No to Silvertown Tunnel [SILV - 227]

Deadline 3 Written Representation to Planning Inspectorate 27 January 2017

We have reviewed the revised versions of the Traffic Impacts Mitigation Strategy (TIMS, REP2-031), the Monitoring Strategy (REP1-121) and the Charging Policies and Procedures (REP1-123). The comments that follow are based on Revision 1 of these documents.

Figure 2-1 Process to determine the need for and mitigation

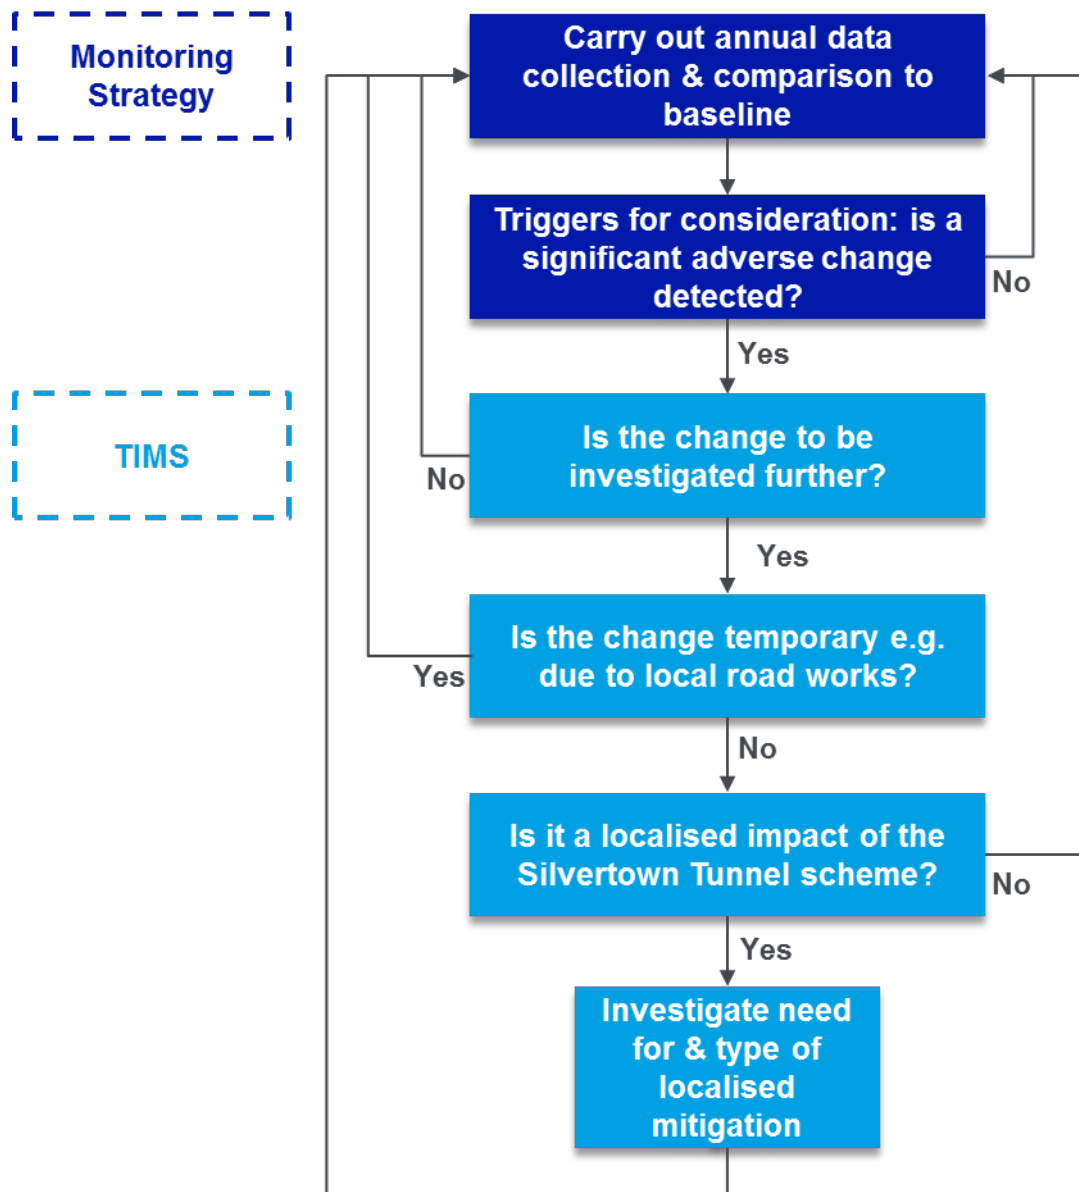
1.1.2. Furthermore, figure 2.4 of TIMS and figure 3.2 of the Monitoring Strategy suggest the scope of issues that might be mitigated is limited to those issues caused by the Scheme.
